SSD-58978472 Aspect Industrial Estate IVE Printing and Packaging Facility (WH8)

I refer to the Department's email of 4 November 2025 regarding the Amendment Report for State Significant Development SSD-58978472 Kelso Crescent Multi-Level Warehouse, Moorebank for 'Fit out and use of the WH8 building for the IVE Group packaging and print operation. The proposal includes a modification to the concept plan including changes to site layout, parking and landscaping requirements' at 20 Kelso Crescent, Moorebank (Lot 1 DP 1296586) in the Liverpool City Council local government area (LGA). Submissions need to be made to the Department by 19 November 2025.

1 GROUND FLOOR / SITE PLAN
1:500 A-600

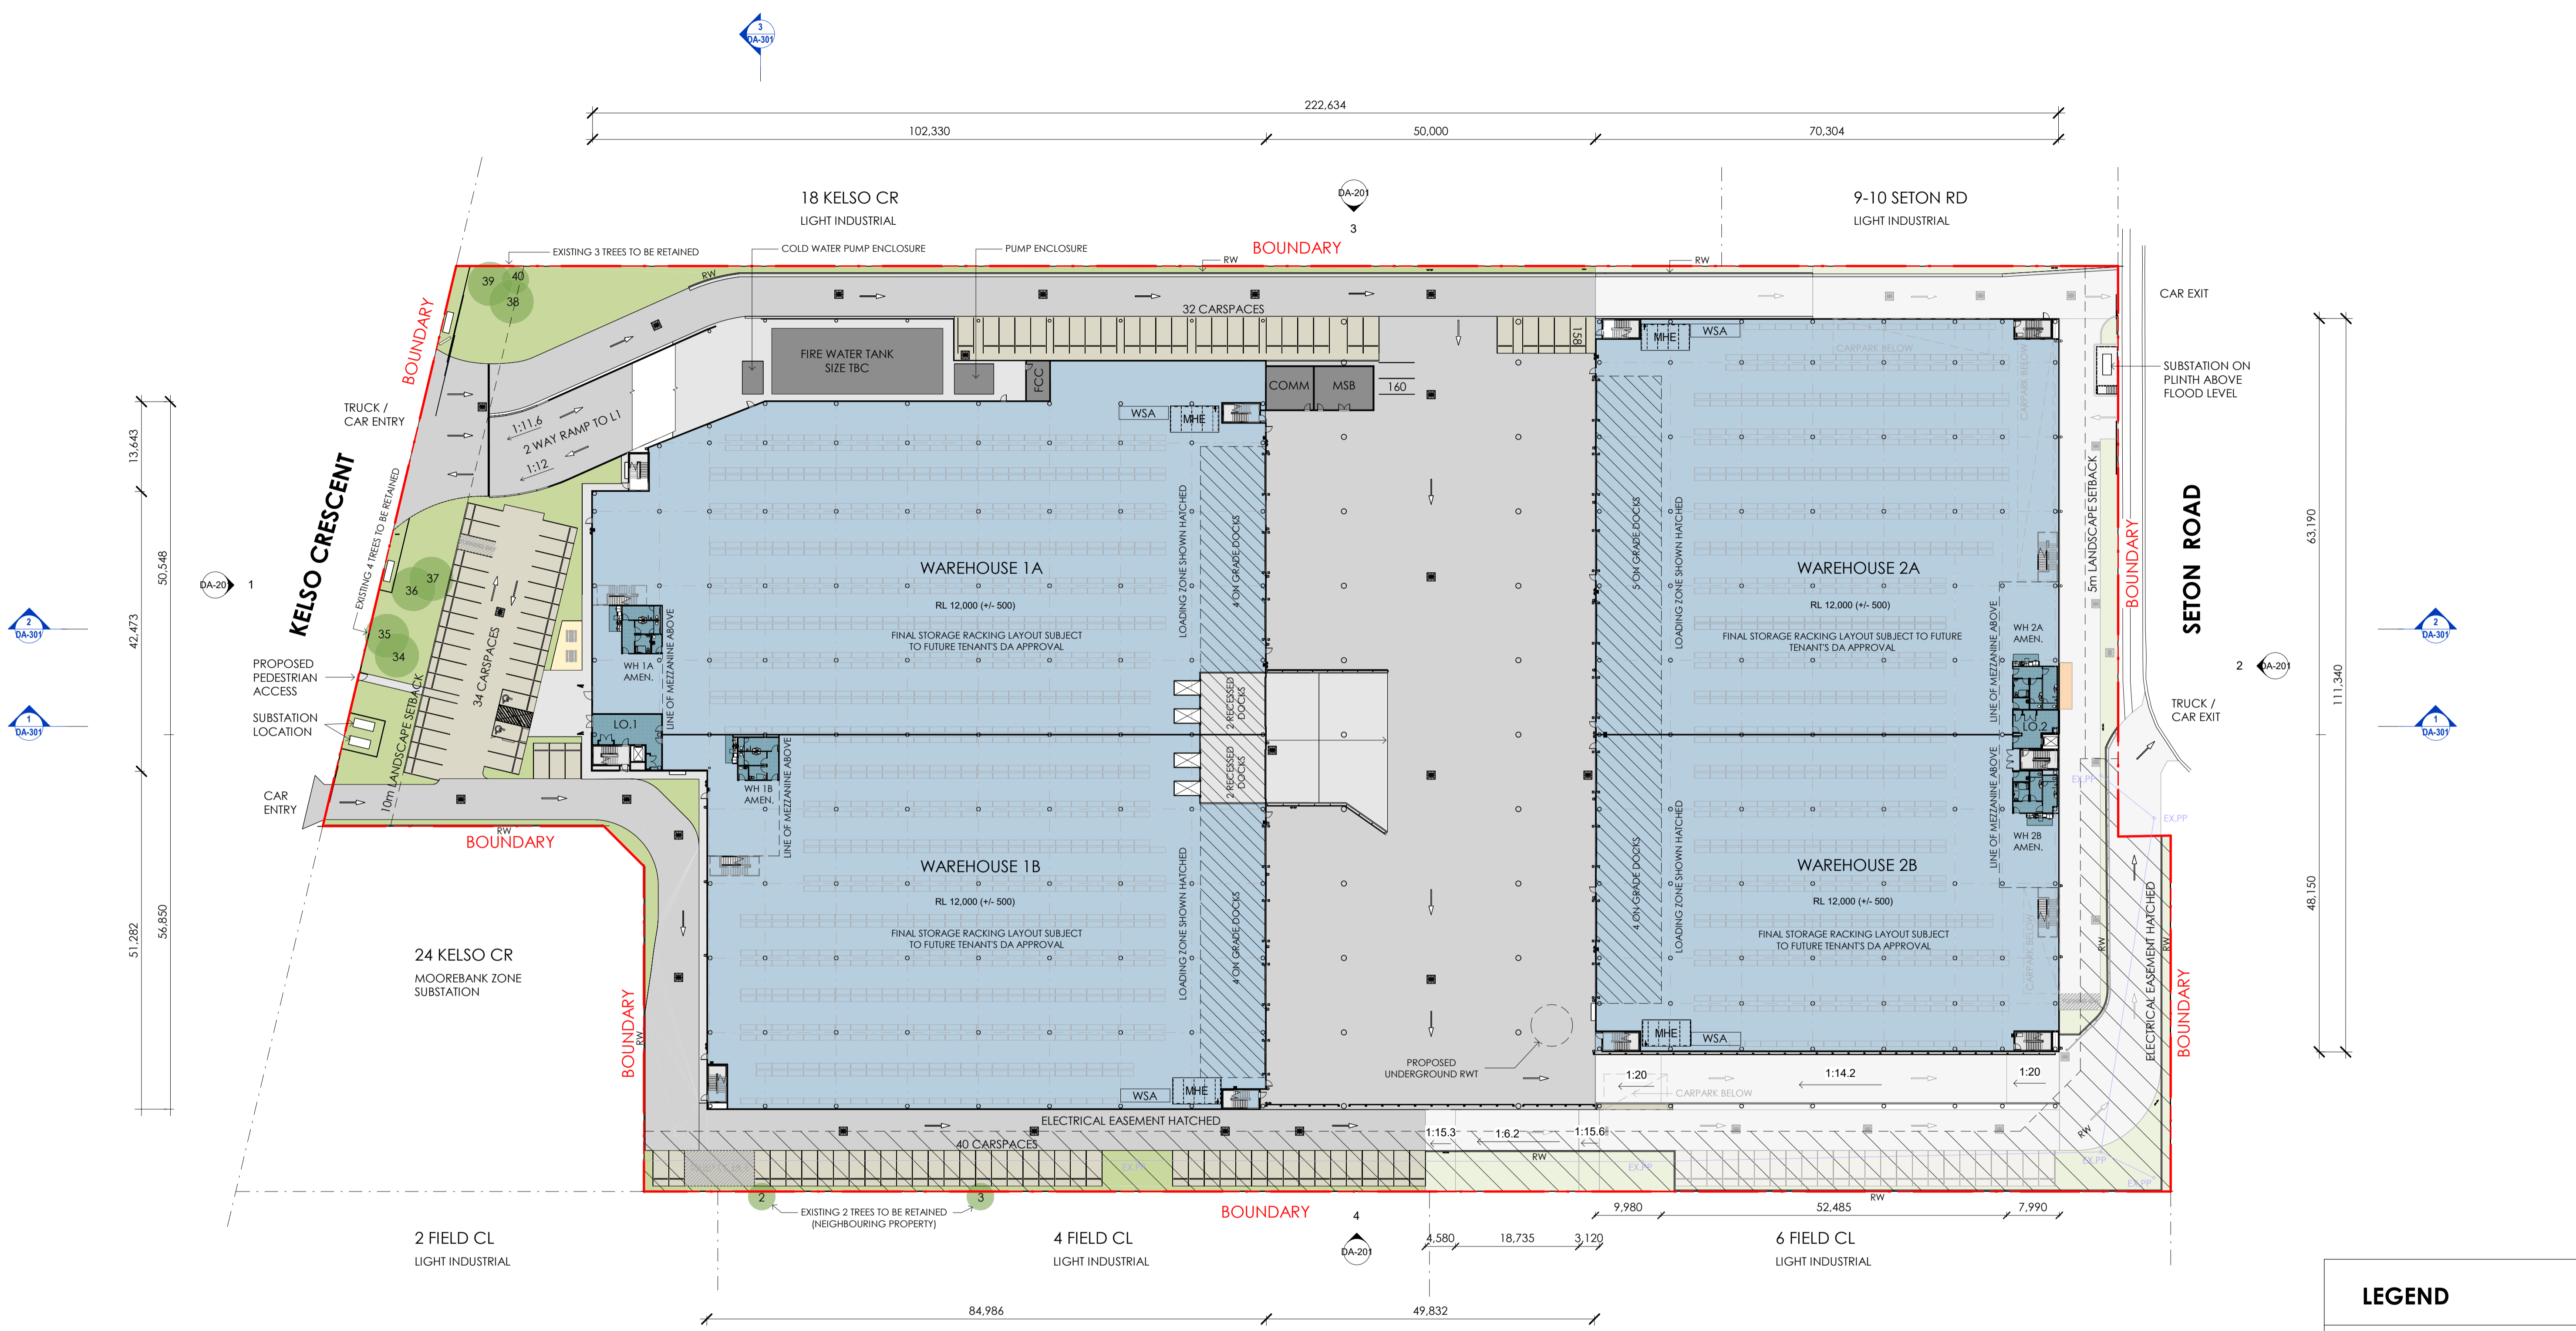
The below copy of the Ground Floor / Site Plan shows provision for three padmount substations and 'Electrical Easement Hatched'.

Any required padmount substation/s will need to be located within the property (in a suitable and accessible location) and be protected (including any associated cabling not located within a public road / reserve) with an appropriate form of property tenure as detailed in the attached copy of Endeavour Energy's 'Land Interest Guidelines for Network Connection'.

Generally it is the Level 3 Accredited Service Provider's (ASP) responsibility (engaged by the developer) to make sure substation location and design complies with Endeavour Energy's standards the suitability of access, safety clearances, fire ratings, flooding etc. If the substation does not comply with Endeavour Energy's standards, the applicant must request a dispensation.
